Geoffrey Lamb
47 Bramble Road
Hatfield
Hertfordshire
AL10 9RZ

14th October 2013

PLANNING APPLICATION: S6/2013/1469/FP

TITLE Proposed Ground & First Floor Plan		
PROJECT NAME Oak Cottage, 4 Wilkins Green Lane, Hatfield, AL10 9RT		
DRAWN BY E.B	DATE SEPT 2013	
SCALE 1:100 @ A1	CHECKED	
DRAWING NO. EL/2012/05	REV. NO. E

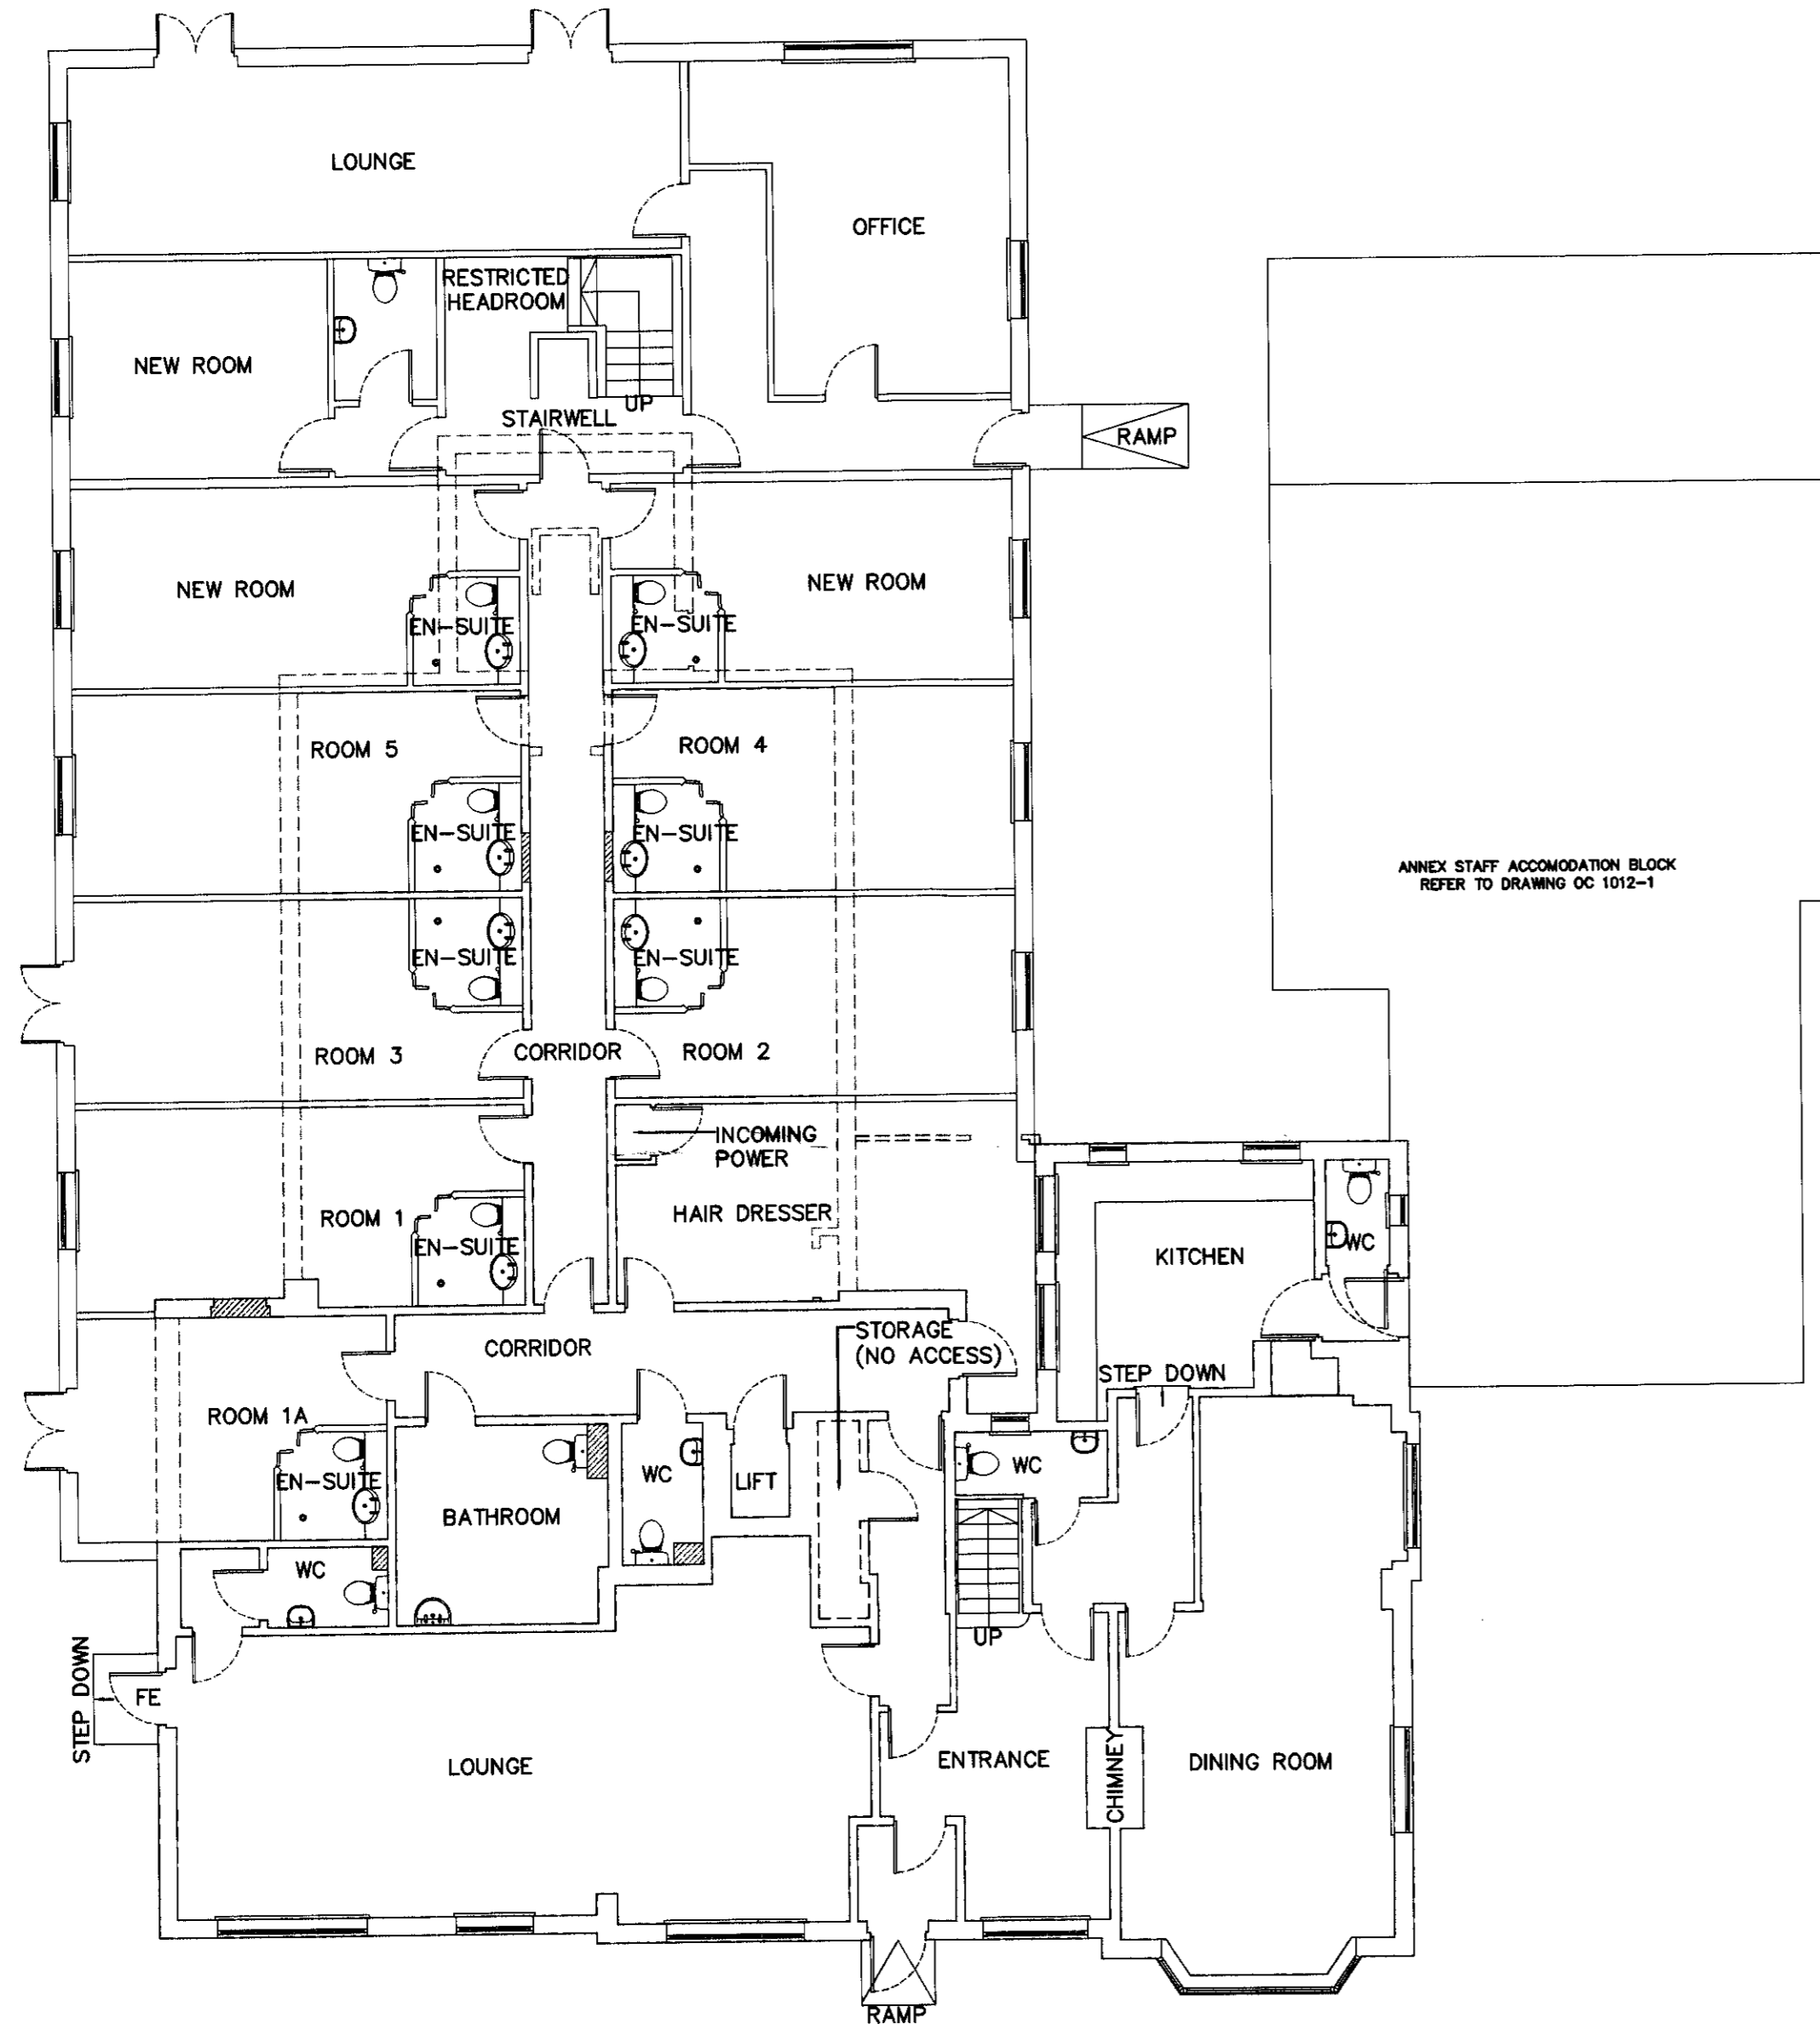
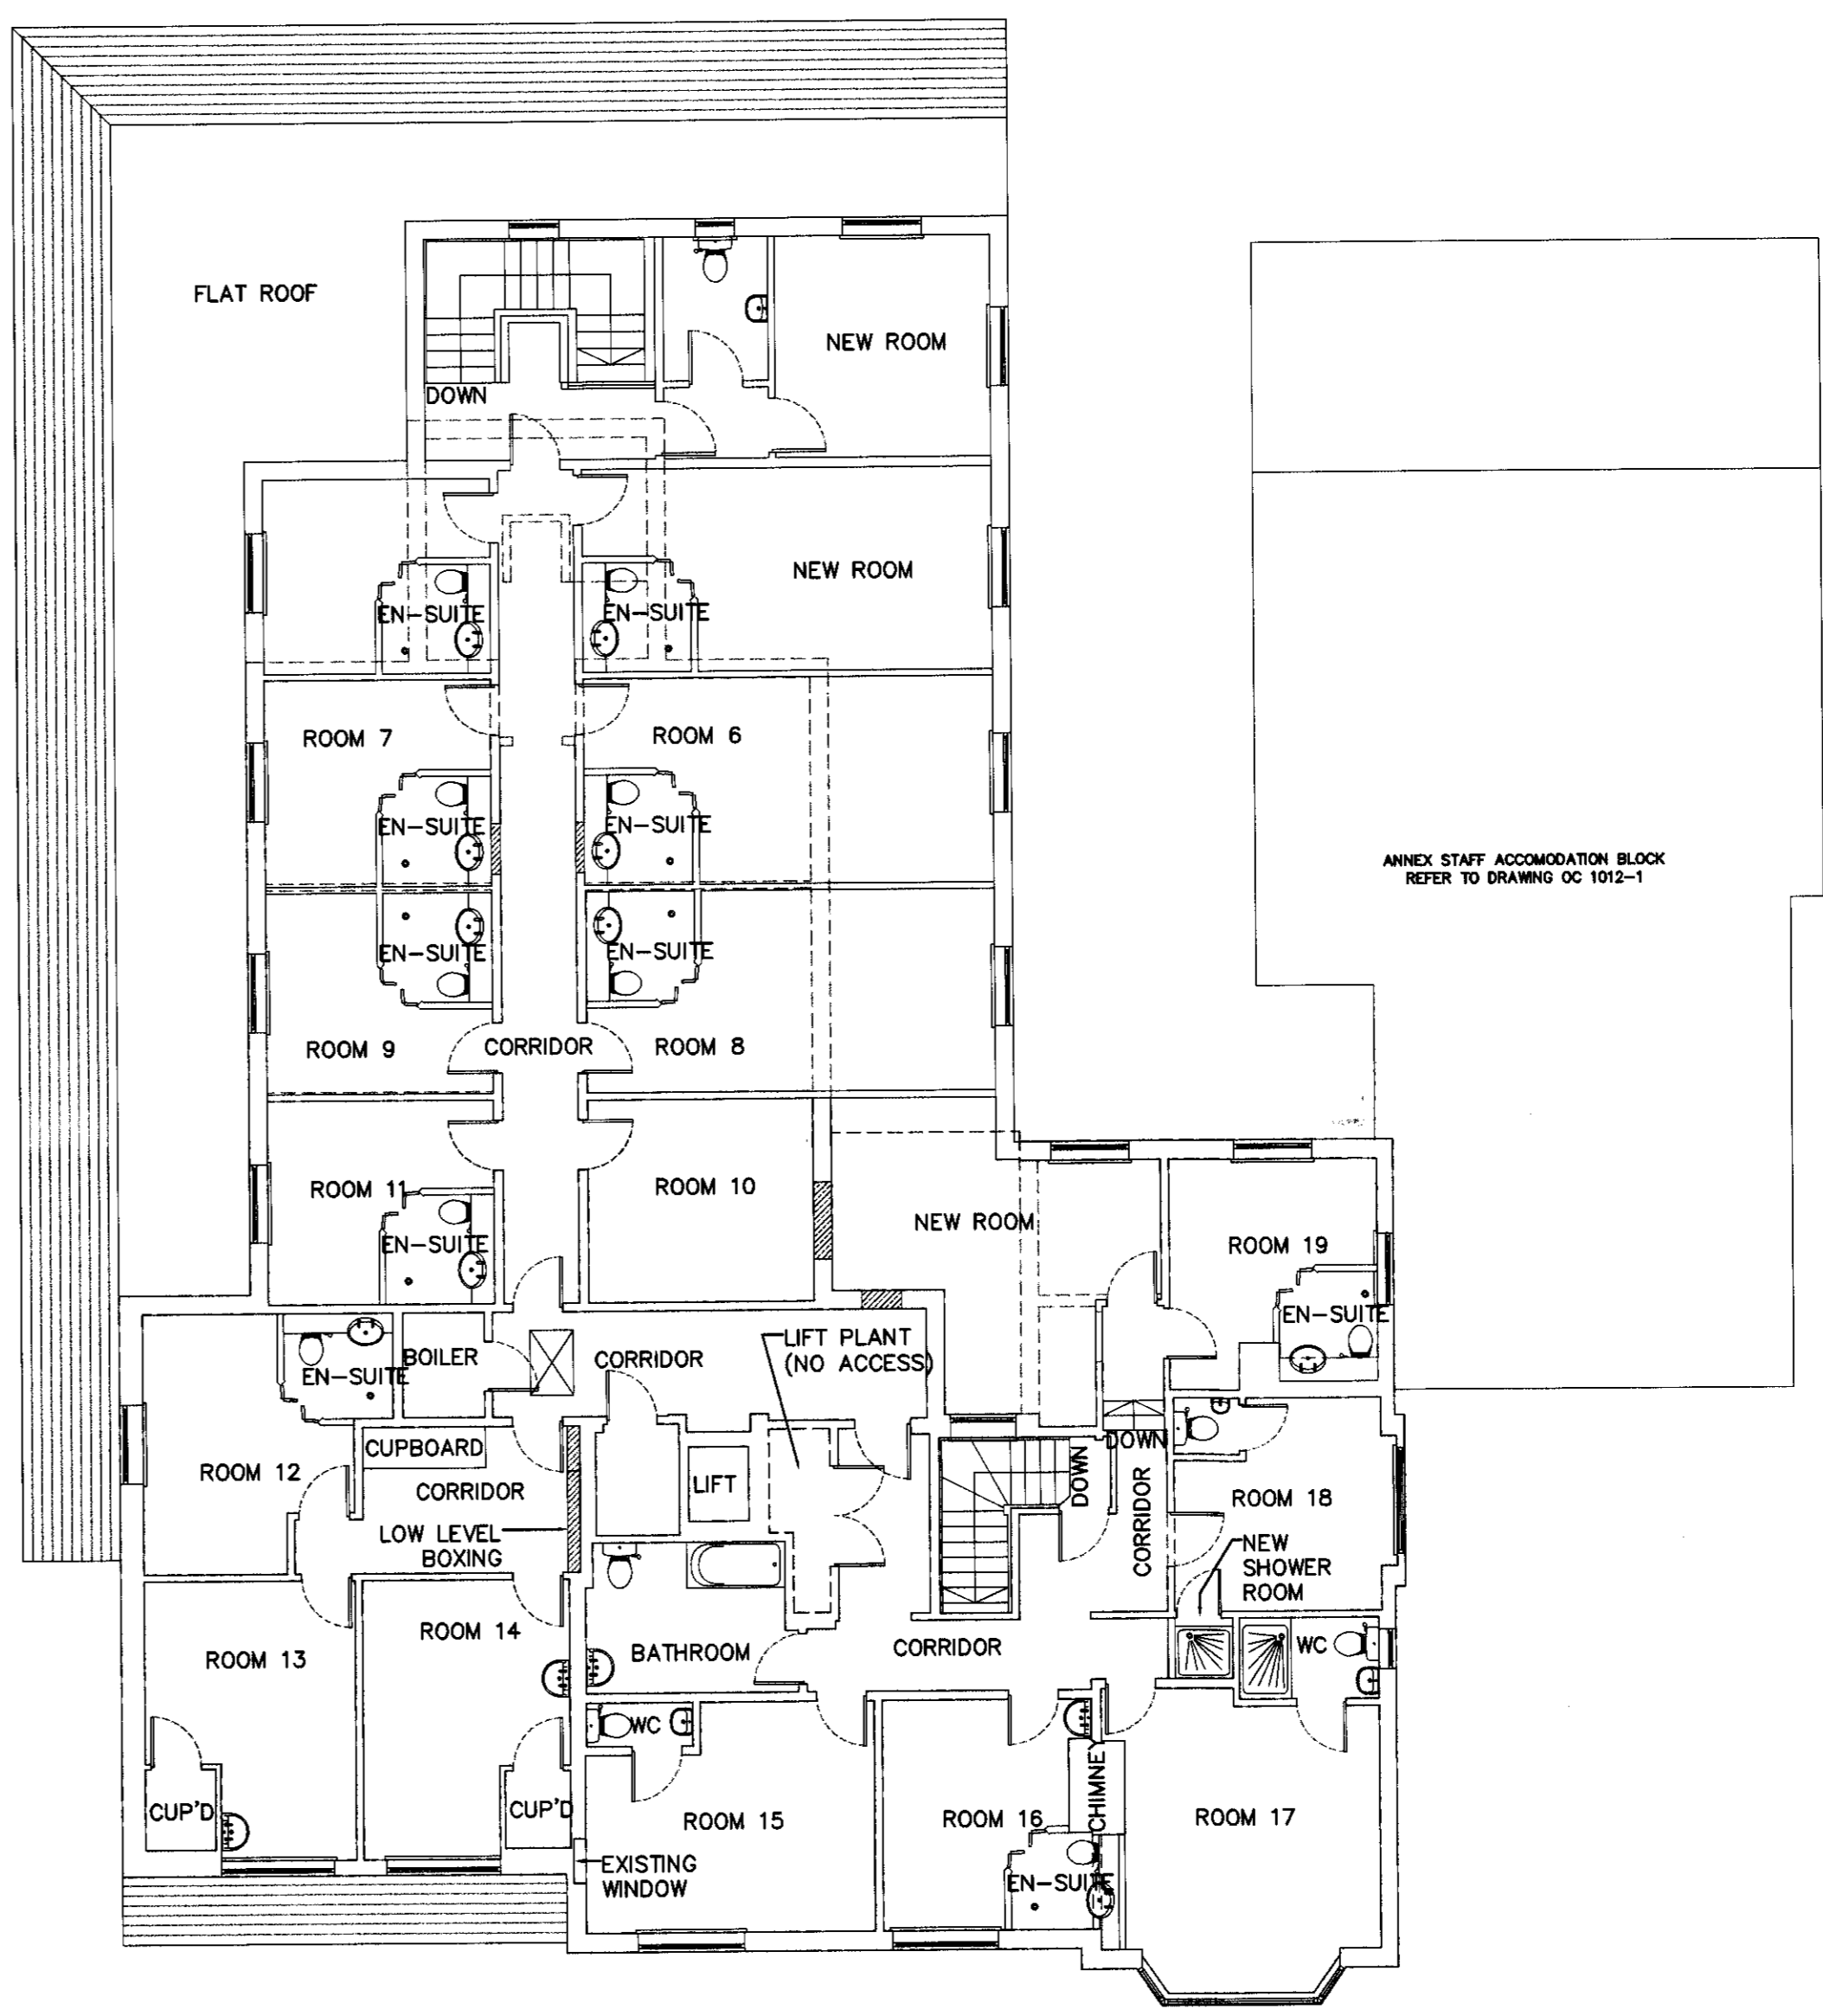
1) Further to my e-mail of 28th August 2013, I have not had a response to my comment that the site and block plans do not show the full picture of the whole site thus making it difficult to comment fully.

There is an "outbuilding" at the bottom right of the garden at Oak Cottage which was the subject of a planning application (ref: S6/2009/2047/FP), including a conservatory, at a full planning committee meeting on 17th December 2009 having been "called in" which I attended, and this should in my view be shown.

Had this been shown it would have been evident that the site is already overdeveloped and not in keeping with other properties in Wilkins Green Lane. So to build another 6 bedrooms would make it even worse.

2) In the original application the "Staff Annex" was not mentioned but suddenly it has appeared.

3) With regard to car parking, this is not an industrial site and the attendant increase in traffic and noise in what is essentially a quiet residential lane, is totally unacceptable. I do not think the front garden should be used as a car park.
